Your Ref: OWPC18014
Our Ref: M/41/18/HH 22-03-2018
Please ask for:
Zac Denton

Extension to 1st floor incorporating rooms within the roof space for new 2nd floor & single storey rear extension with balcony above.

25 Sea Way Middleton-On-Sea

PROPOSED ELEVATIONS

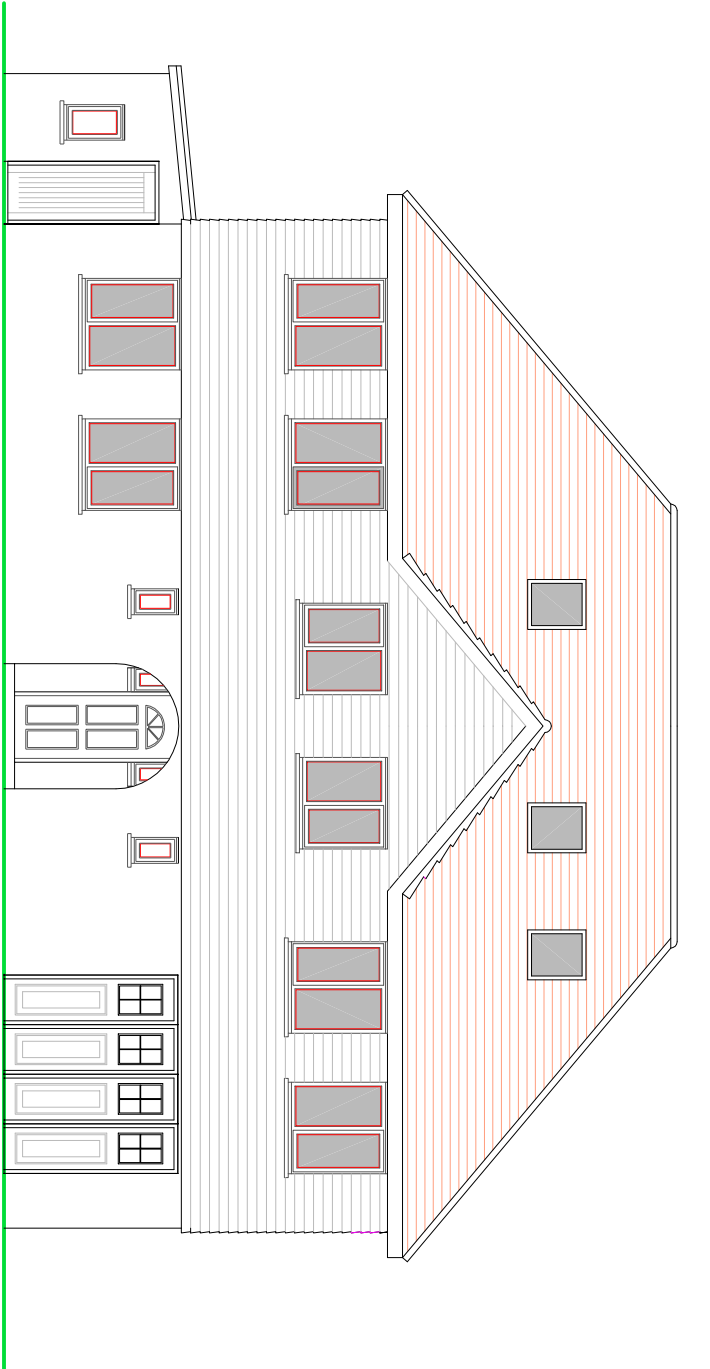
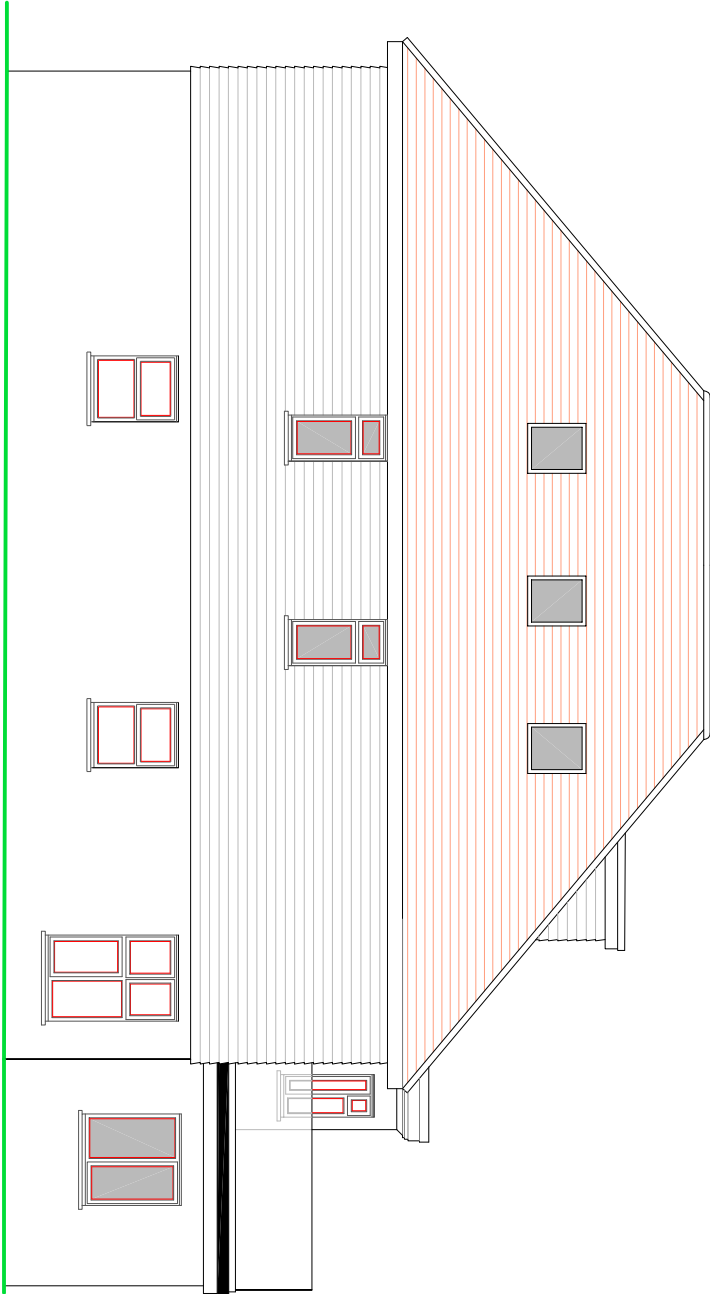
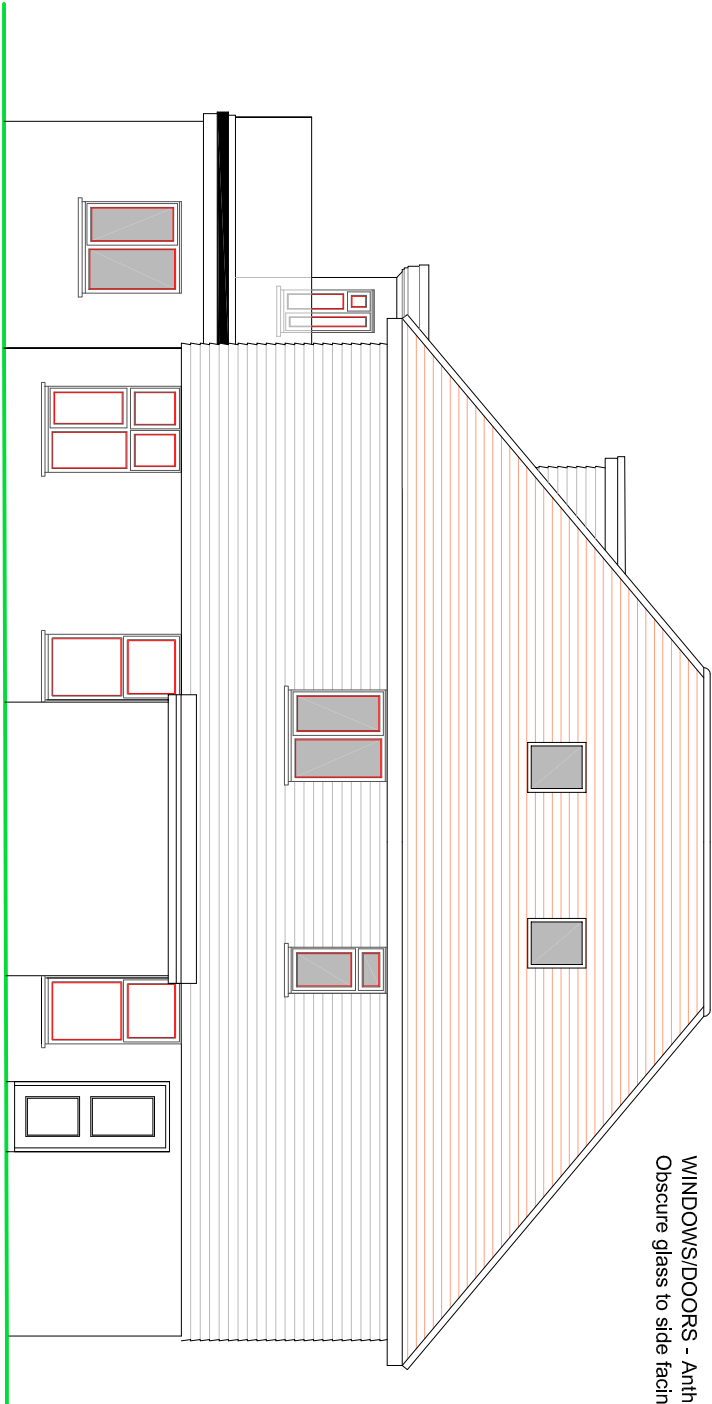
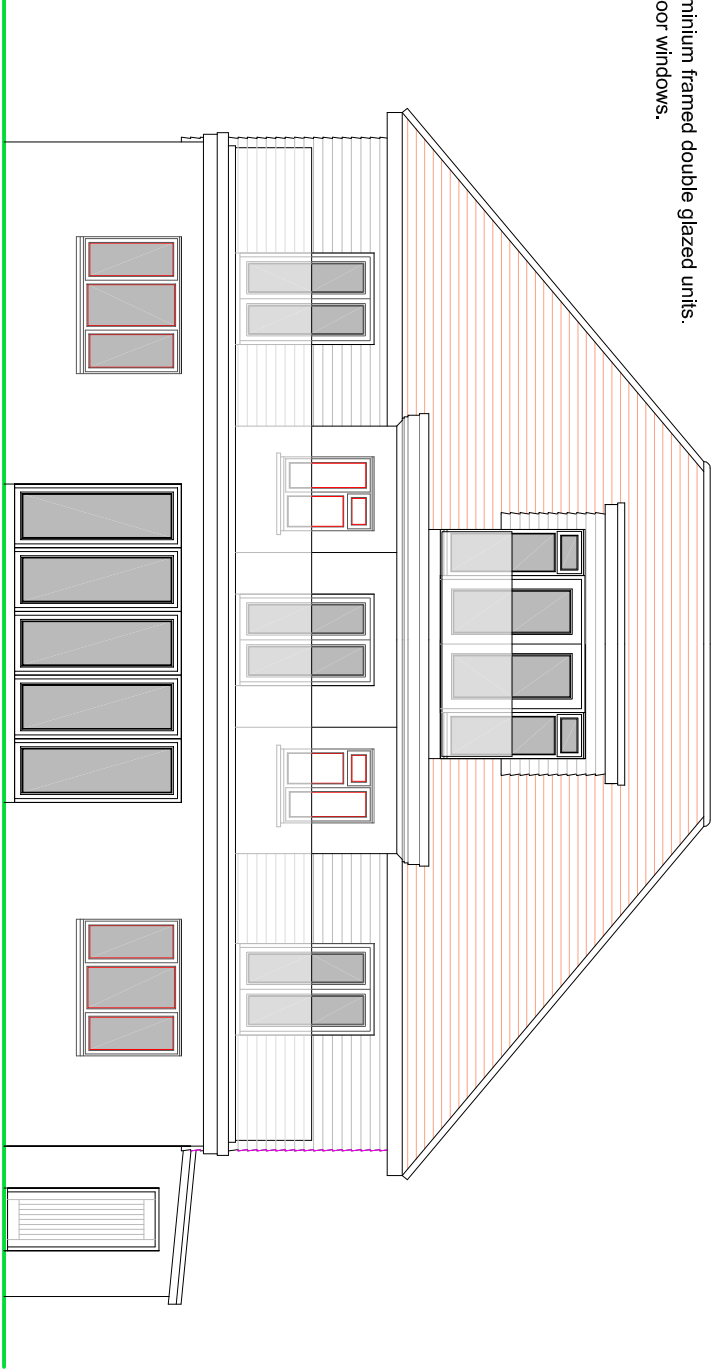
Although a modest increase in the original footprint of the dwelling is proposed, the height and bulk shown in the plans would amount to an overdevelopment. Approval of this application would therefore be contrary to ADC planning policies that have been adopted to prevent unneighbourly developments. Approval would also fail to protect the area designated by ADC as an Area of Special Character, which includes Sea Way. There would be serious invasion of privacy to the dwelling to the east and compromise to the privacy for the property to the west. Very clear guidance exists for developers in the 'Village Design Statement', which has been adopted by, and has been relied upon by, the Council. That guidance states that three floors in private dwellings are really unacceptable. Although some use might be made of 'loft space', the proposals in M/41/18 go further, raising the height of the building to enable a large third floor area, contrary to the planning guidance. I hope that Arun District Council Planning refuses the application to preserve the legitimate expectations of privacy of other residents and to protect the Area of Special Character.
